From: Andrew Wood
Sent: 15 January 2019 15:01
To: Planning.Responses
Subject: FW: CM/33/18/PL The Barn, Grevatts Lane
Attachments: 597-101_Location Plan_12.12.18.pdf; 597-102_Existing Plans_12.12.18.pdf; 597-103_Existing Elevations_12.12.18.pdf; 597-104_Proposed Plans_12.12.18.pdf; 597-105_Proposed Elevations_12.12.18.pdf; 597-106_Street Elevation.pdf

Re; Replacement Dwelling at The Barn, Grevatts Lane . ref CM/33/18/PL

Site & Floor Plans_Existing
Dwg. No. 597-102

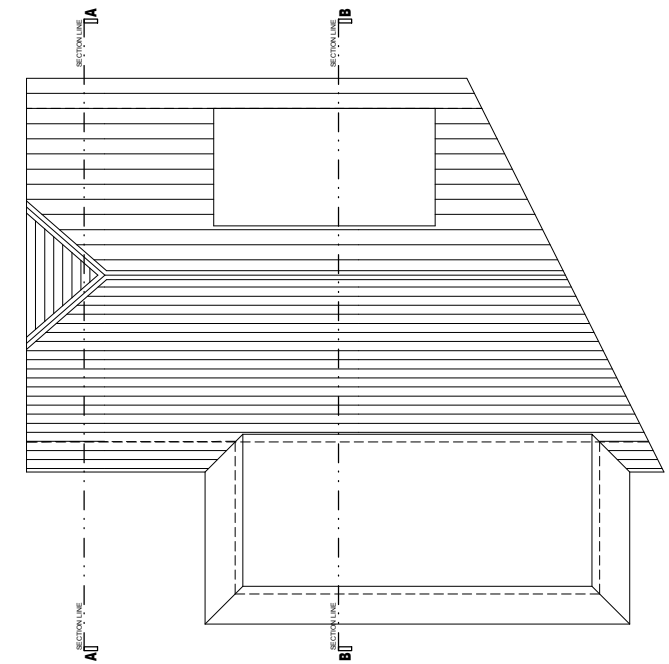
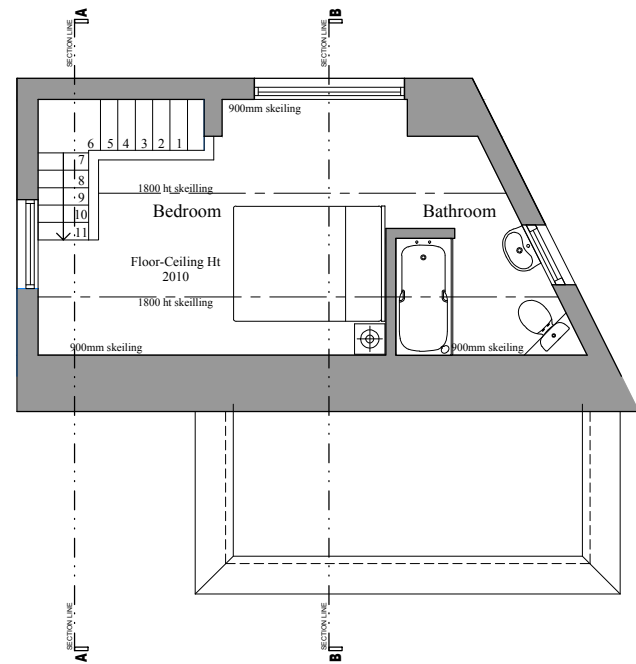
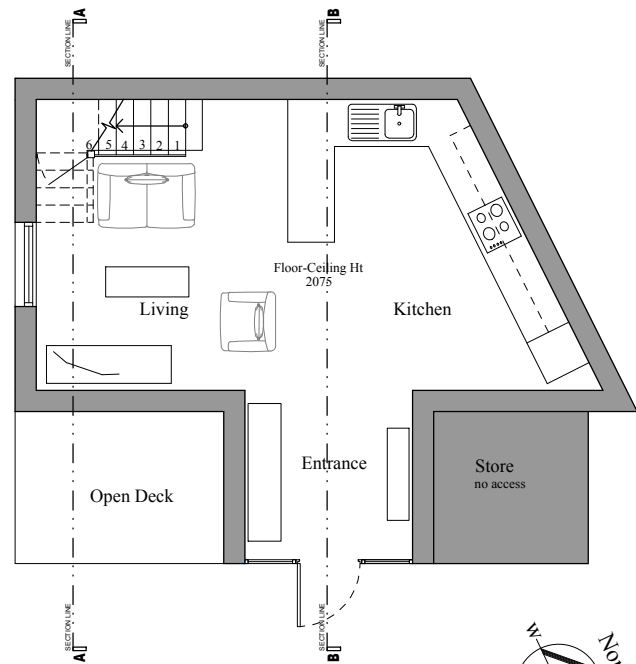
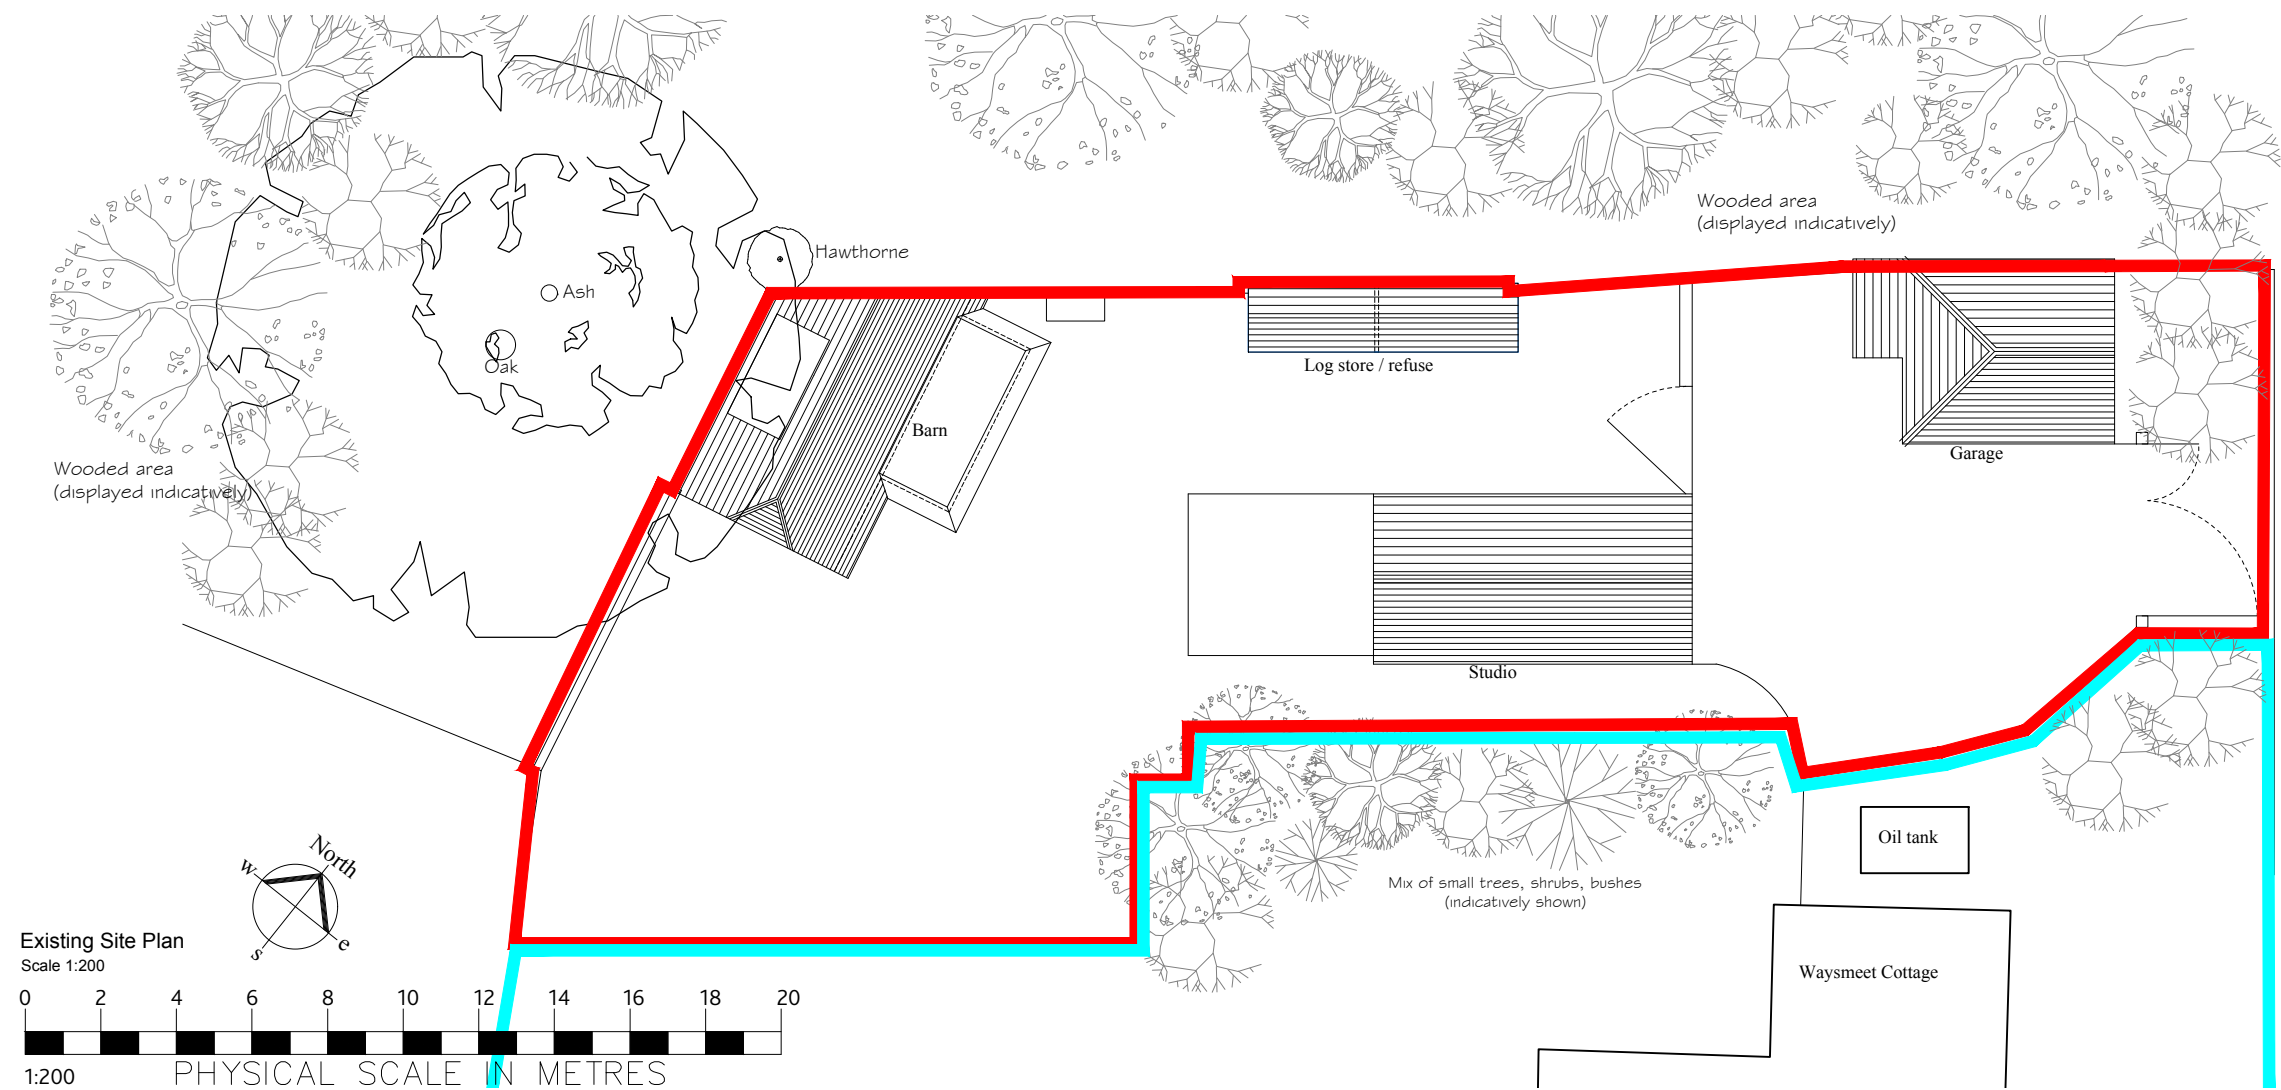
My general feeling regarding this application is that it is heading towards a refusal on the grounds of poor design due to overdevelopment and impact on the residential amenity of 'The Studio'. It might be worth having a face to face meeting at the Council Offices to discuss the scheme. If you concur with this view please do contact me with a potential meeting times/dates and I will set the meeting up.

Following on from the below e-mail please see the attached drawings displaying the site boundary including the Studio as part of the curtilage to the replacement dwelling. The elevations and floor plans show that the balcony has been removed to reduce your concerns of overlooking, albeit any over looking issue with the Studio has now been negated.

Further to your below email to Kevin, and our subsequent telephone conversation this morning, I have just been advised by my client that they would agree to including the studio within the curtilage of The Barn, thus ensuring only one residential unit is on the site. This I understand would negate your concerns of over development and impact on the residential amenity of the studio, as this would now be ancillary accommodation to the main house.
